CITY OF ALBUQUERQUE

Re: Dorado Montano Townhouses
5915 Golden NW
Traffic Circulation Layout
Architect's Stamp 06-01-20 (E10-D079)

Based upon the information provided in your submittal received 06-09-20, the above referenced plan cannot be approved for Building Permit until the following comments are addressed:

SHEET CIVIL101A

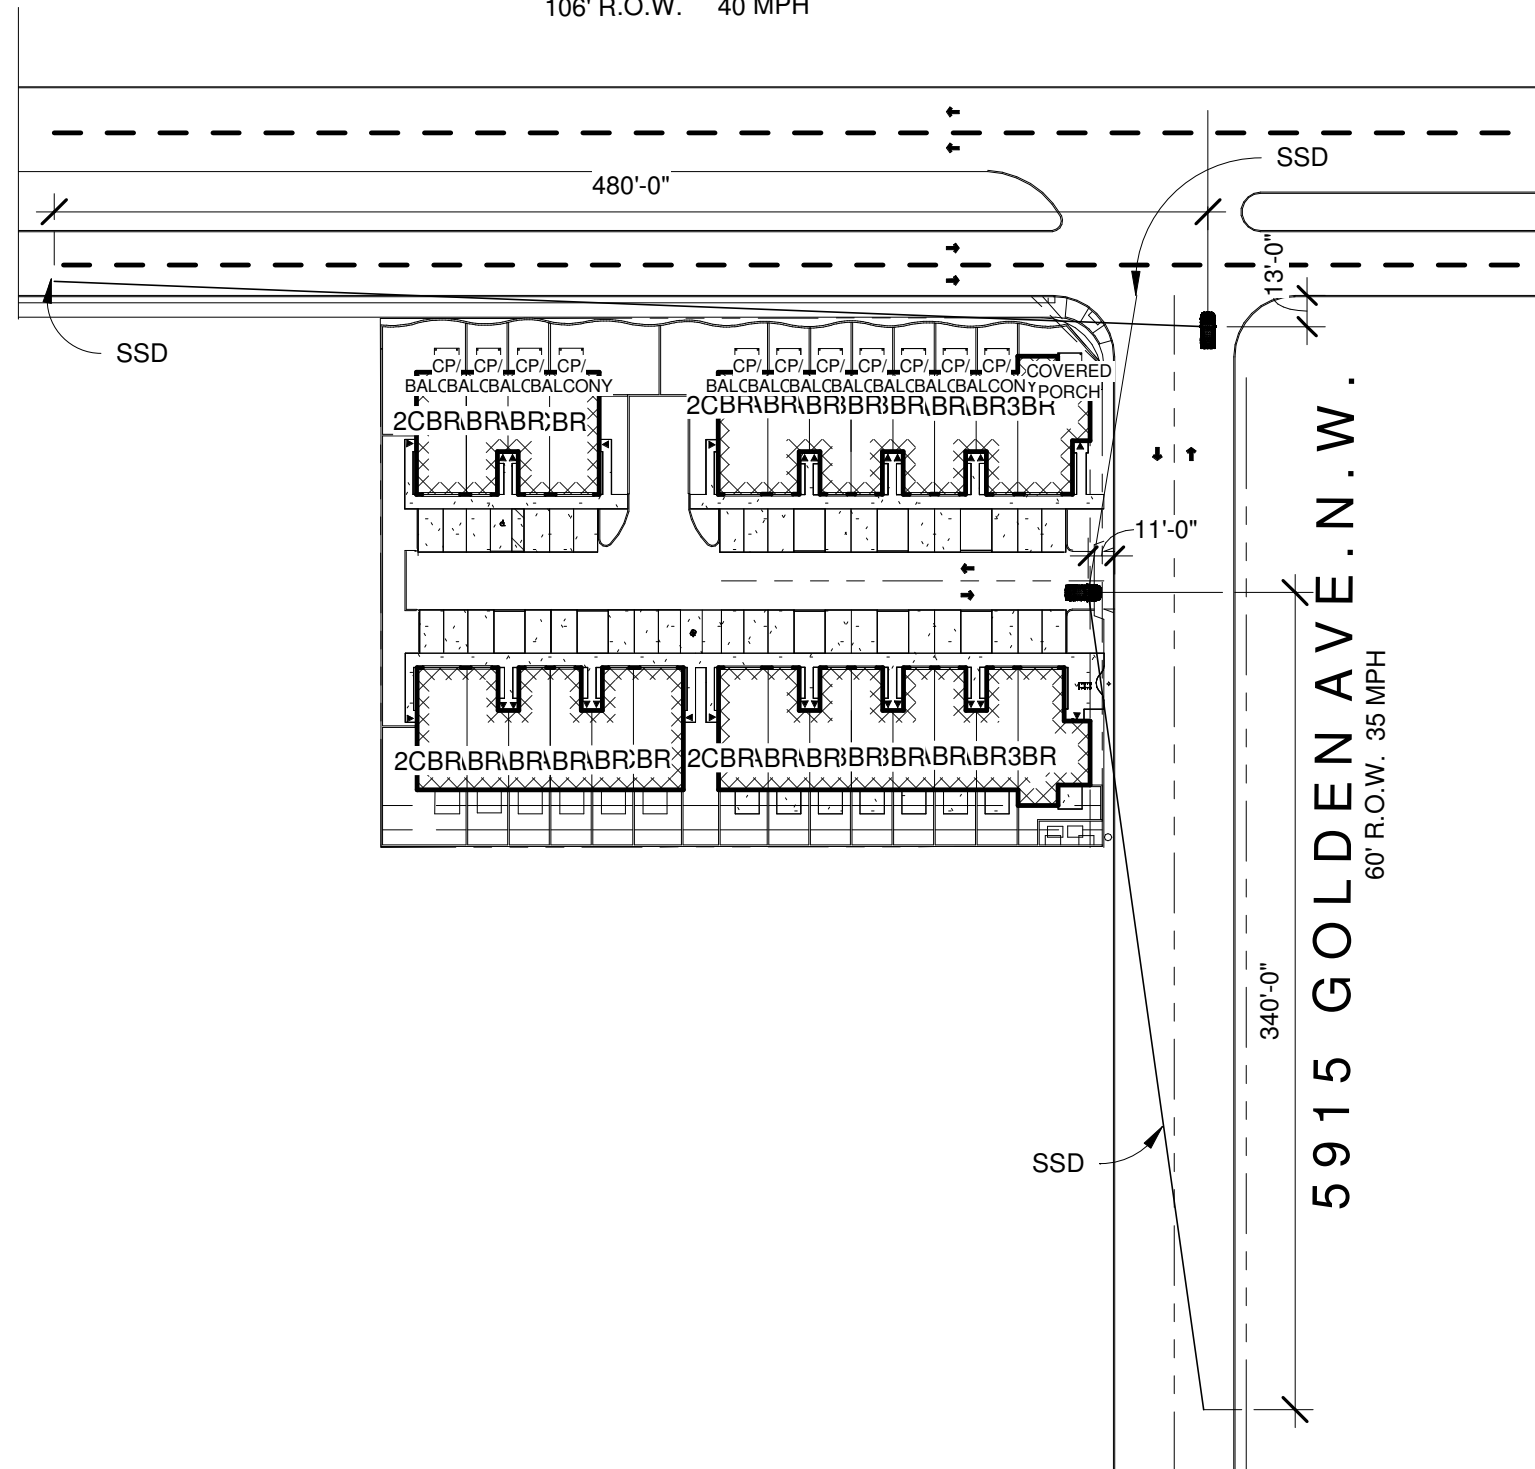
8. Please provide a intersection sight distance exhibit (See attached exhibit):
 - For Golden Ave and the proposed 3 ft block wall on Montano Road
 - For drive aisle and proposed 3ft block wall on Golden Ave

SEAL: [Professional Engineer Seal]
 DATE: MARCH 2020
 PROJECT NO.: THY152
 DRAWING NO.:
CIVIL101
 6/1/2020

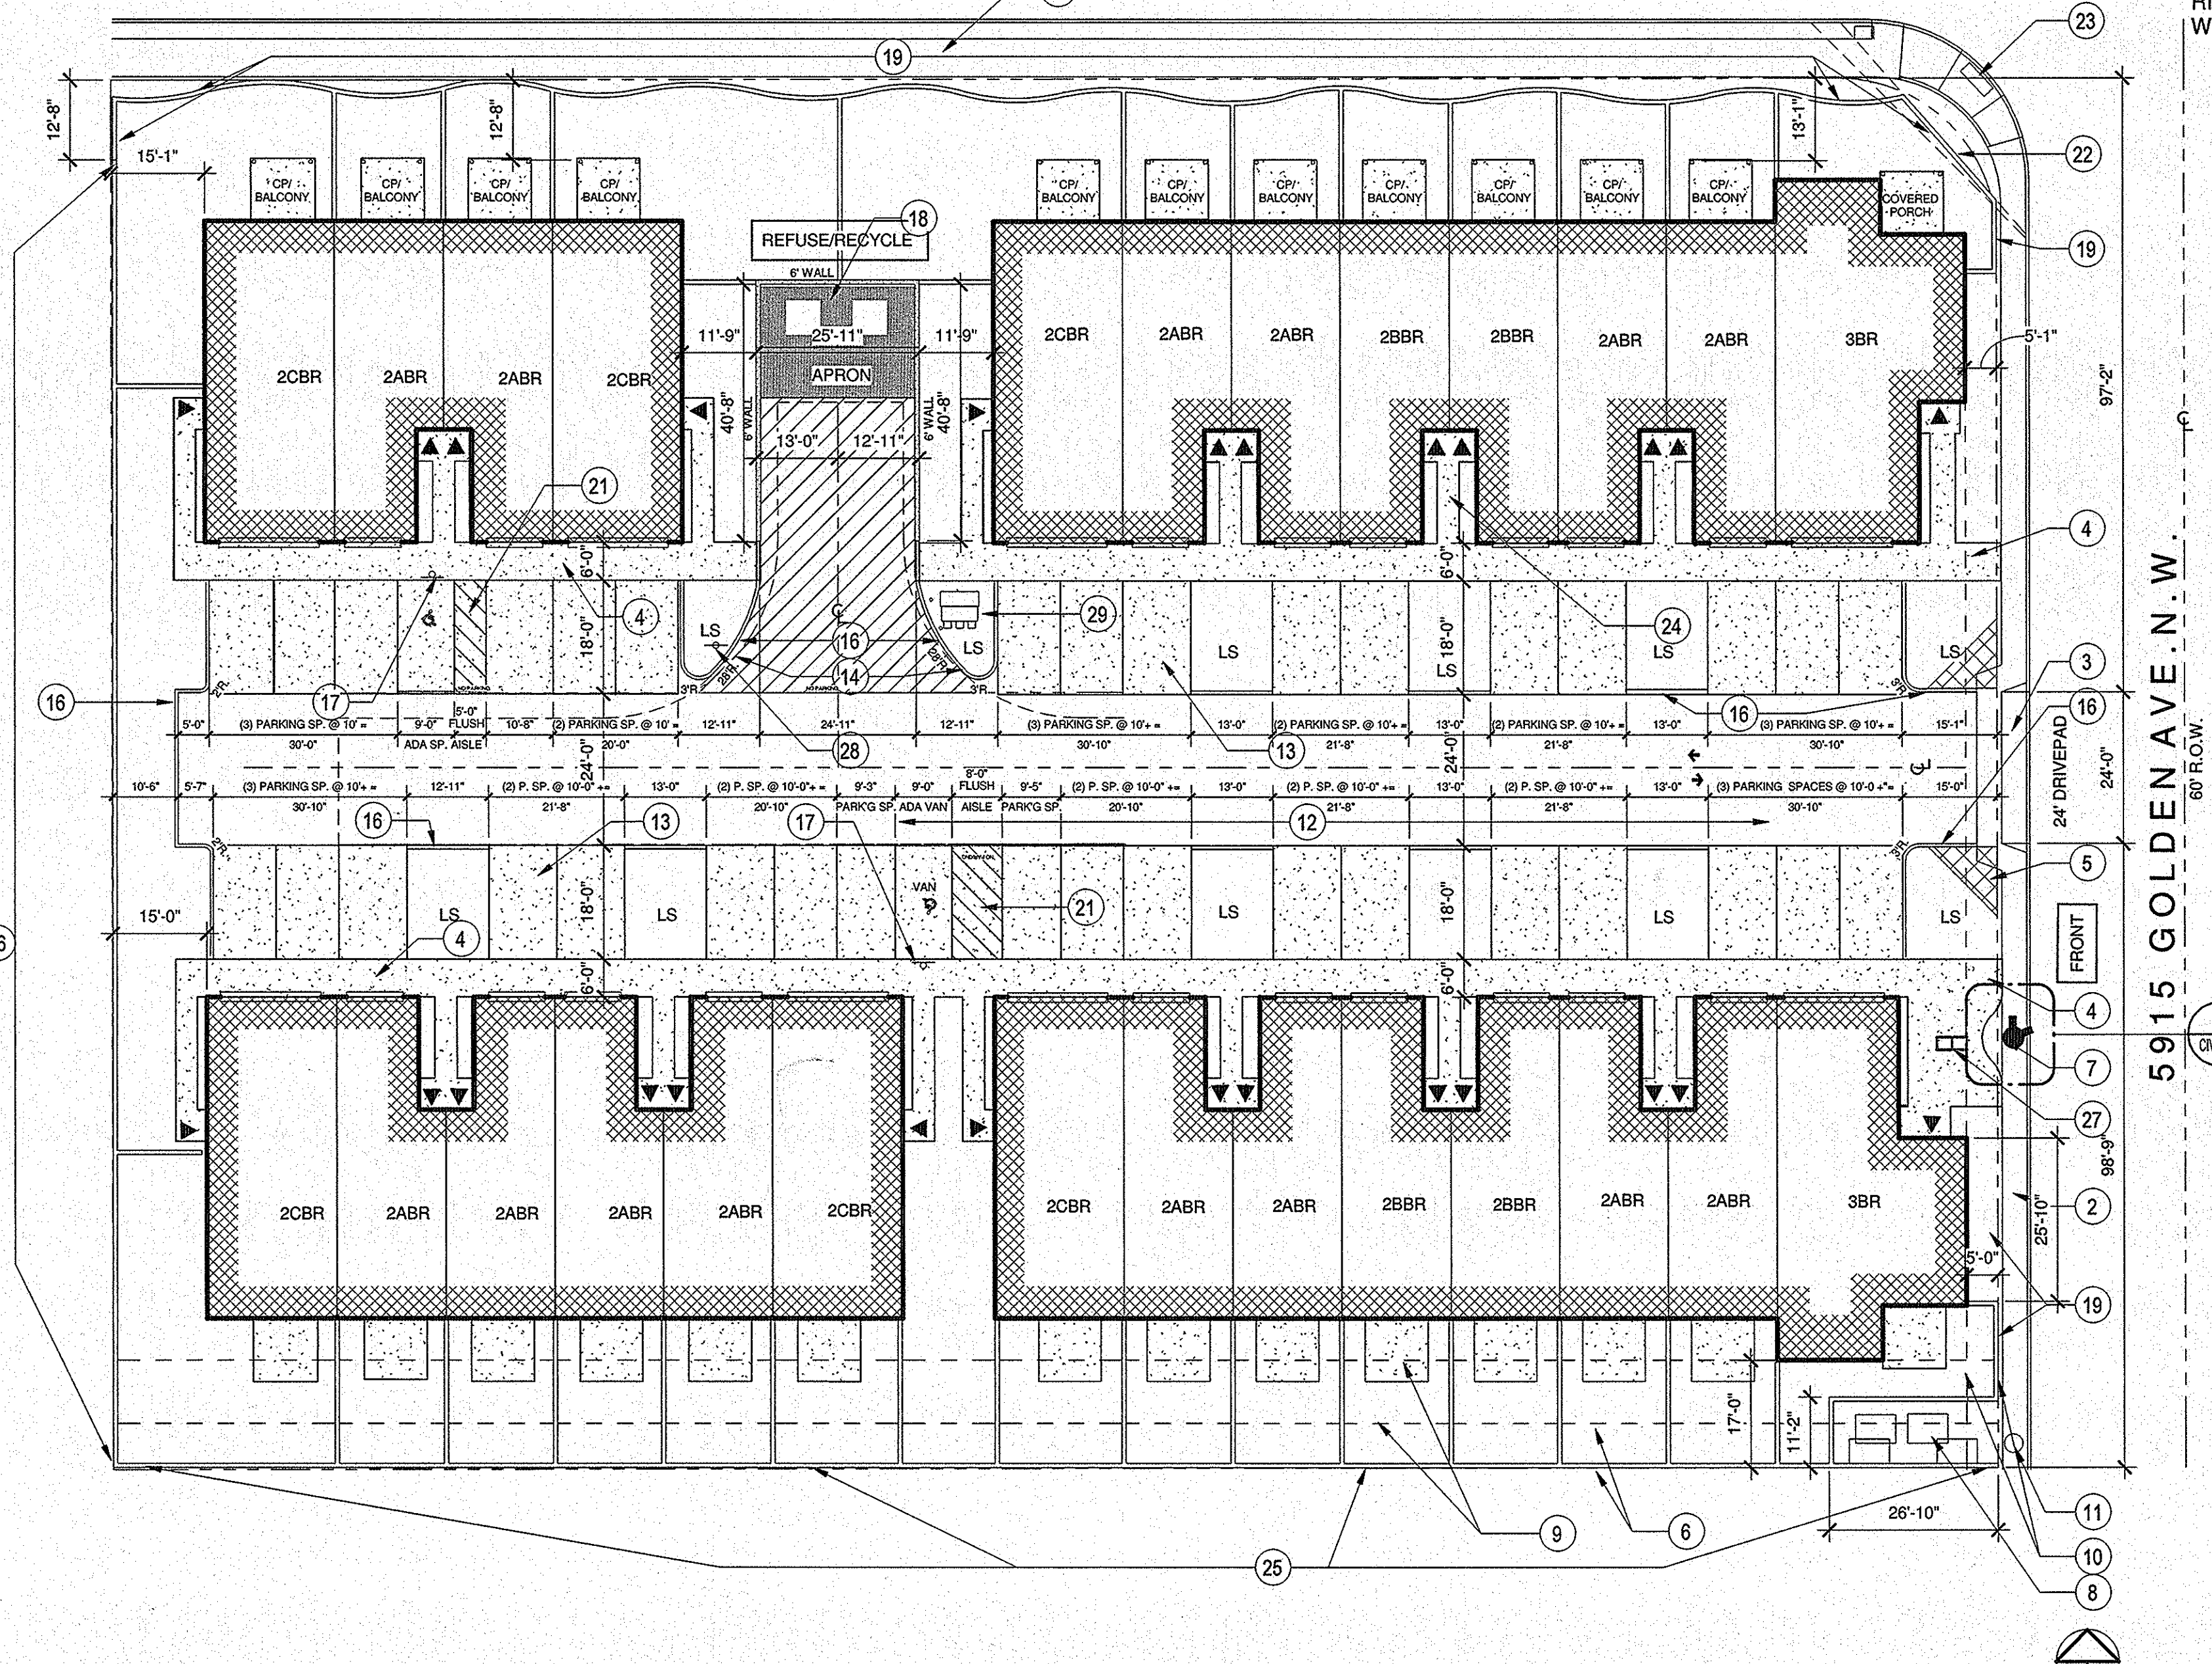
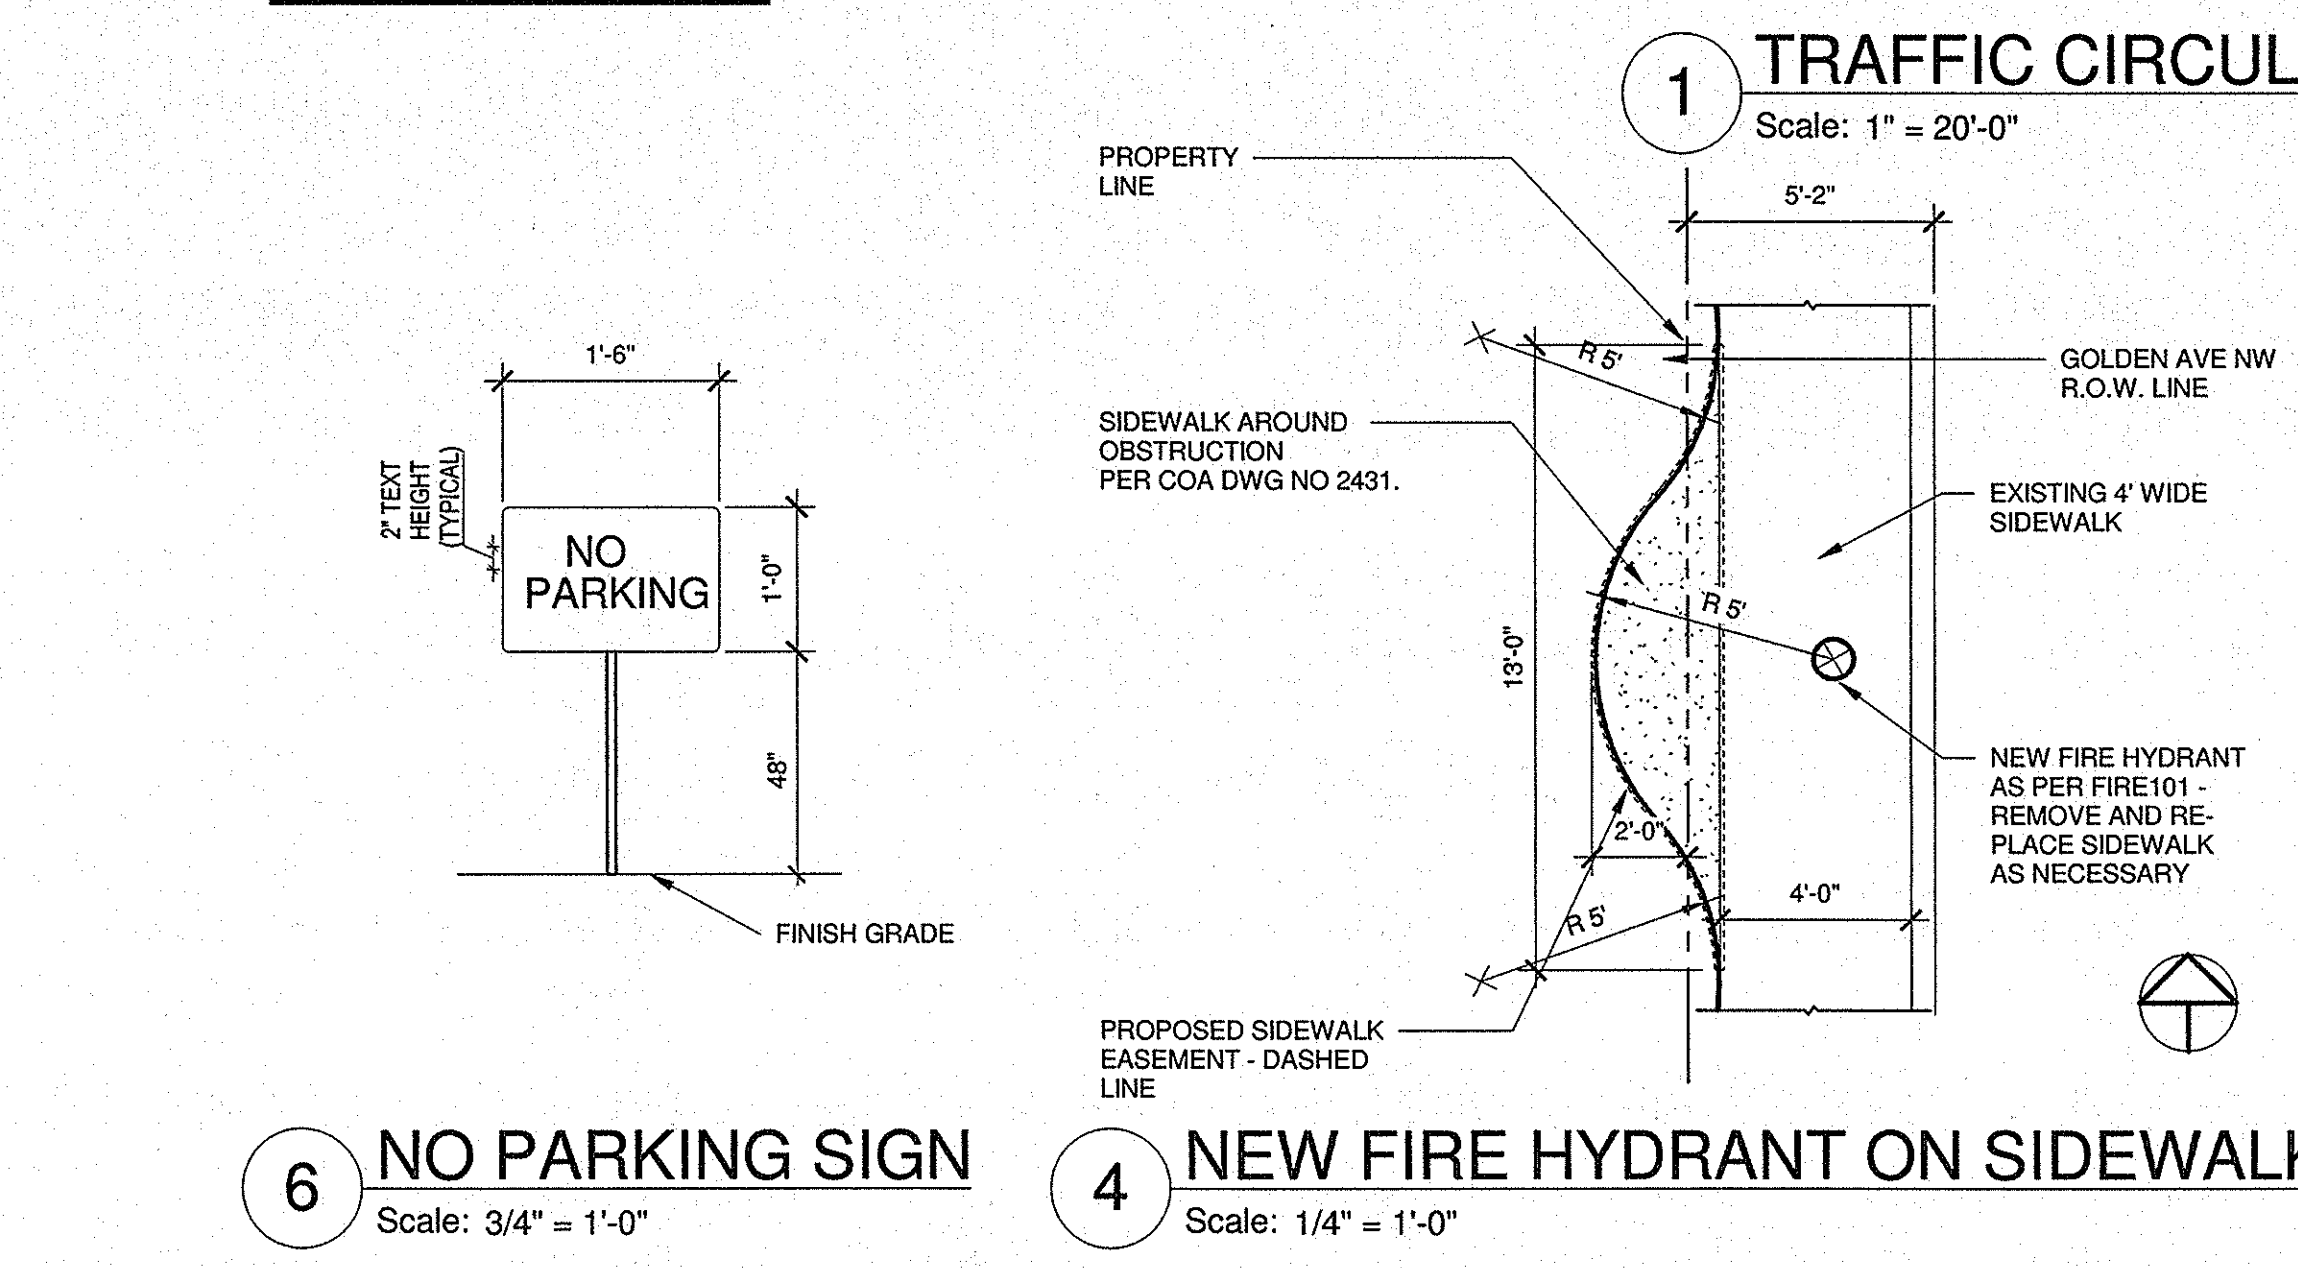
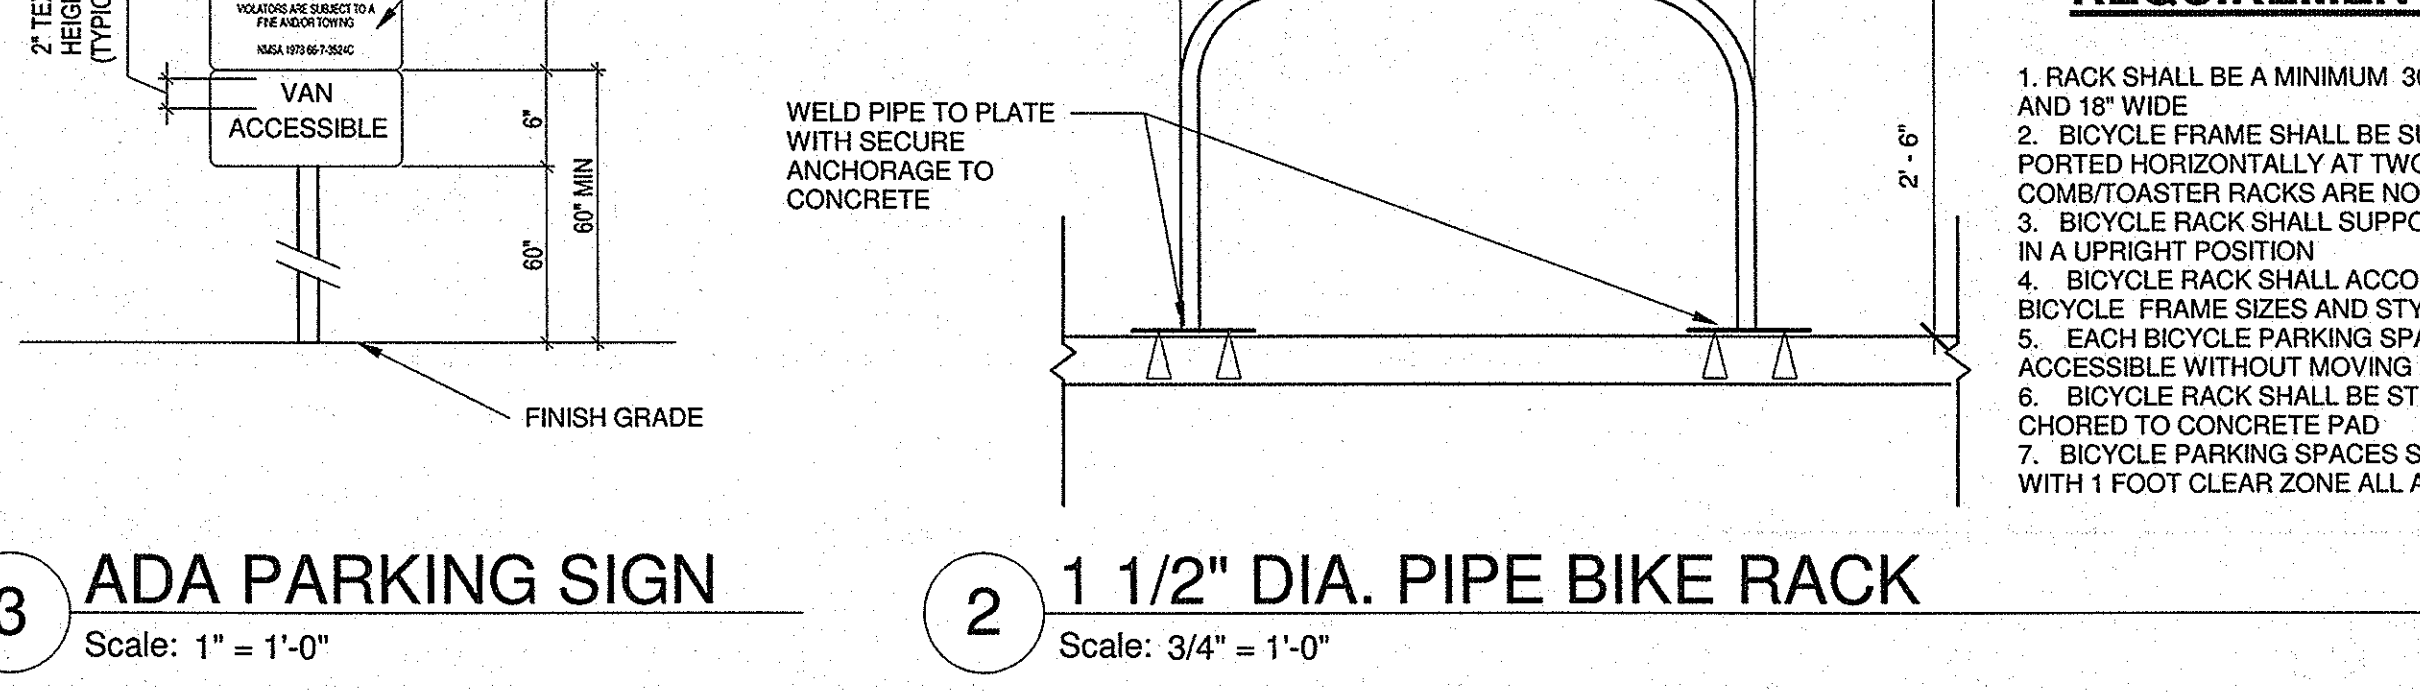
1. Please coordinate all calculations for parking spaces, including bicycle and motor cycle parking with Zoning and list the number required. Please verify.
2. The minimum parking stall dimensions are:

Will this be a problem if you overhang is 2 ft and your proposed 6 ft. ADA pedestrian pathway You see, 2 ft overhang will reduce the proposed 6 ft pathway to 4 ft. This will be a problem. Please clarify.

3. The 6 ft. wide ADA accessible pedestrian pathway from the public sidewalk to the building entrances will need to be unstripped thru proposed Fire and Refuse drive aisle.
4. ADA parking stall signage panel, for the 5 ft access aisle, is facing the wrong direction. But, Per DPM, a 6 ft. wide ADA accessible pedestrian pathway is required from the ADA parking stall access aisles to the building entrances not 5ft. Please clearly show this pathway and provide details.
5. The proposed curbing around proposed landscape and parking with need to encompass the perimeter of the landscaping on all proposed landscaping islands.

6. Parking areas shall have barriers to prevent vehicles from extending over proposed 6ft wide ADA pedestrian pathway/sidewalk.
7. Provide a copy of refuse approval for design and location of proposed refuse container.

9. Show the clear sight triangle and add the following note to the plan:
"Landscaping and signage will not interfere with clear sight requirements. Therefore, signs, walls, trees, and shrubbery between 3 and 8 feet tall (as measured from the gutter pan) will not be acceptable in the clear sight triangle.

10. Keyed Note 17: References 3/Civil 101 but you already provided a detail on the proposed TCL sheet. Please clear this issue.
11. Provide Keyed Note 2.

12. Provide existing sidewalk width along Golden Ave.
13. Keyed Note 3: How will you provide 3ft ADA pathway across proposed driveway? Provide detail showing ADA pathway.

14. Keyed Note 7: Please show how you will provide a clear pathway around proposed fire hydrant. Look at COA STD DWG 2431.
15. Please specify the City Standard Drawing Number when applicable.
